Rezoning Transportation Analysis
Petition Number: Insert Zoning Petition #2020-194
General Location Identifier: Tax ID 11906424

Revision Log:	Date	Description
	01-21-2021	First Review (KP)

SHEET
REZONING PLAN
RZ.01

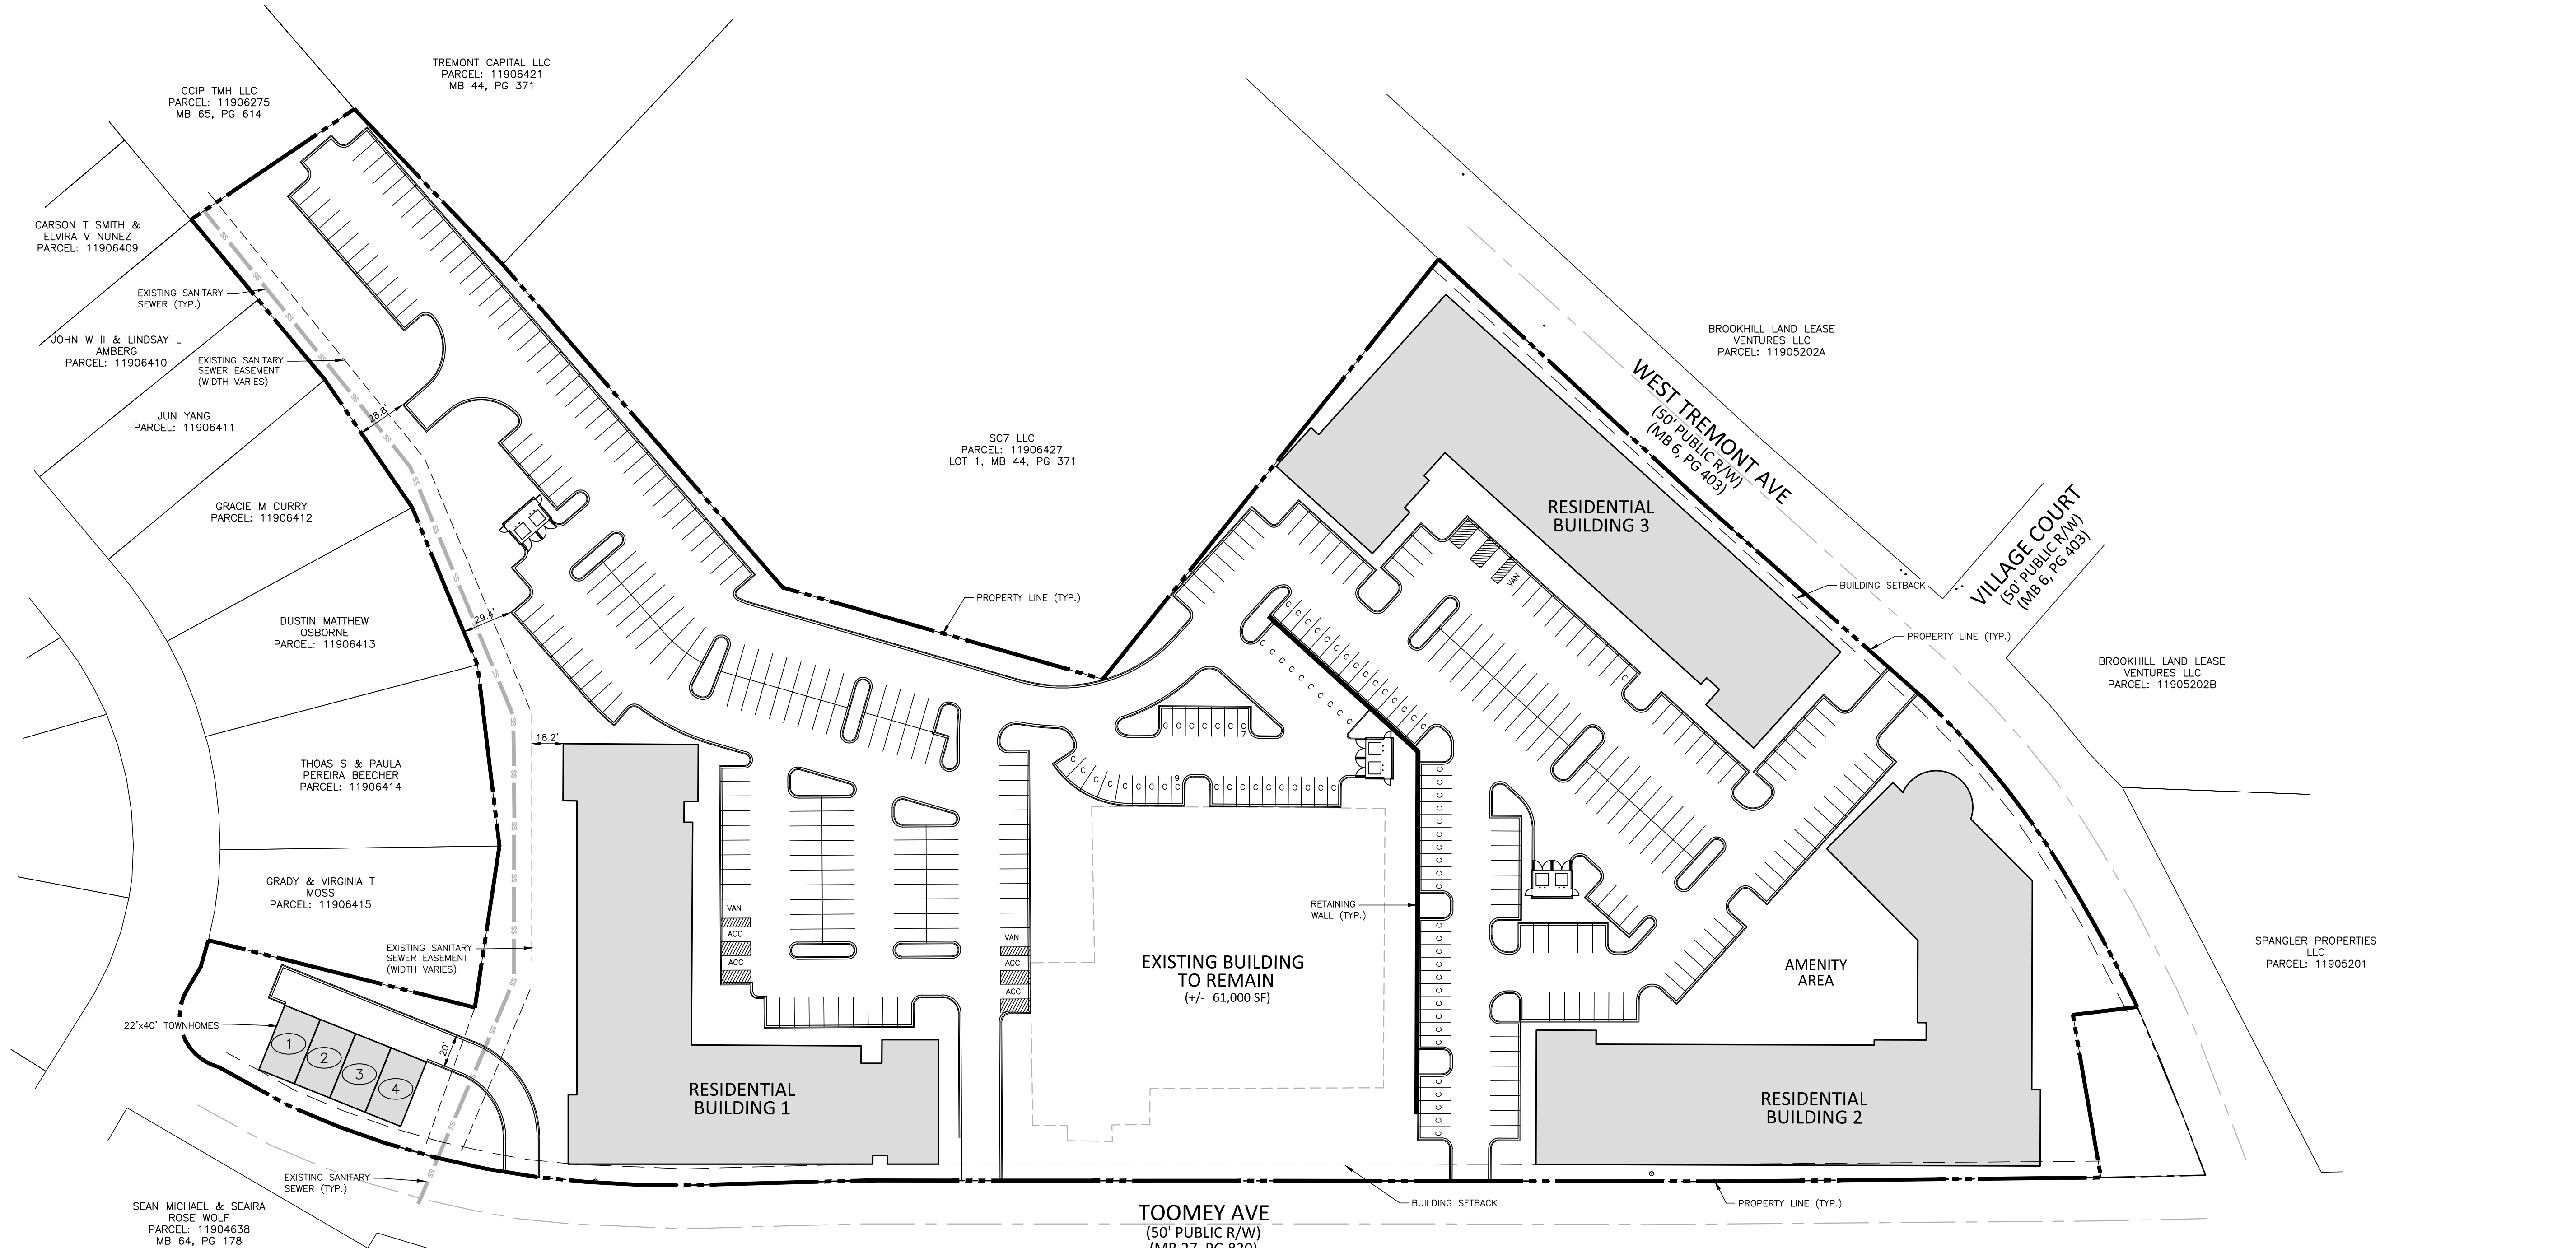
- a. **Toomey Avenue:** Revise the site plan to relocate the curb and gutter 18-feet from the existing road centerline to back of curb, in line with the City's TOD Commercial Wide Street Section (U-05D).
- b. **Tremont Avenue:** Revise the site plan to relocate the curb and gutter 18-feet from the existing road centerline to back of curb, in line with the City's TOD Commercial Wide Street Section (U-05D)

Label and dimension the curb and gutter from the centerline for each road on the site plan.

- 3. In accordance with the City's TOD Commercial Wide Street Section (U-05D), revise site plan and conditional note(s) to commit to dedicate 36.5-feet of right-of-way, from the existing roads' centerline, along the site's Toomey Avenue and Tremont Avenue frontages. The site plan shall label and dimension the right-of-way from the road centerline.
- 4. Revise site plan and conditional note(s) to commit to construct an 8-foot sidewalk, and 8-foot amenity zone, with concrete tree wells, along the site's frontage of Tremont Avenue and Toomey Avenue. Label and dimension both items from the back of curb and gutter and road centerline.

5. Revise the site plan and conditional notes by committing to connecting the curb and gutter, 8-foot planting strip, and 8-foot amenity zone to the curb and gutter, 8-foot amenity zone and 8-foot sidewalk associated with Rezoning Petition 2020-151, which is the adjacent property on Tremont Avenue.

6. Revise the site plan by including the linework for the driveway cuts on the opposing side of Toomey Avenue. Additionally, the petitioner will align the centerlines of the driveways, associated with this site, with the driveways on the opposing side of Toomey Avenue as much as feasibly possible.

7. Revise the site plan and conditional notes by committing to coordinating with the property owner of the parcel at the northeast corner of Tremont Avenue and Toomey Avenue (PID: 11906426), to

extend the streetscape (curb and gutter, 8-foot amenity zone, and 8-foot sidewalk) through the property's frontage of Toomey Avenue and Tremont Avenue. Additional driveway cuts and parking accommodations may need to be negotiated with the property owner to accommodate their site's needs.

8. Revise the site plan and conditional notes by committing to incorporating on-street parking along the site's frontage Toomey Avenue and Tremont Avenue, in accordance with the CLDSM Detail(s) 50.09C and 50.09D (as necessary).
9. Revise the site plan and conditional notes by committing to coordinate with Mecklenburg County Parks and Recreation to create a connection to the Irwin Creek Greenway that runs along the south side of Tremont Avenue.

10. Revise site plan and conditional note(s) to commit to construct a CLDSM 10.31A curb ramp at the southeast corner of the Toomey Avenue and Wilmore Drive intersection.
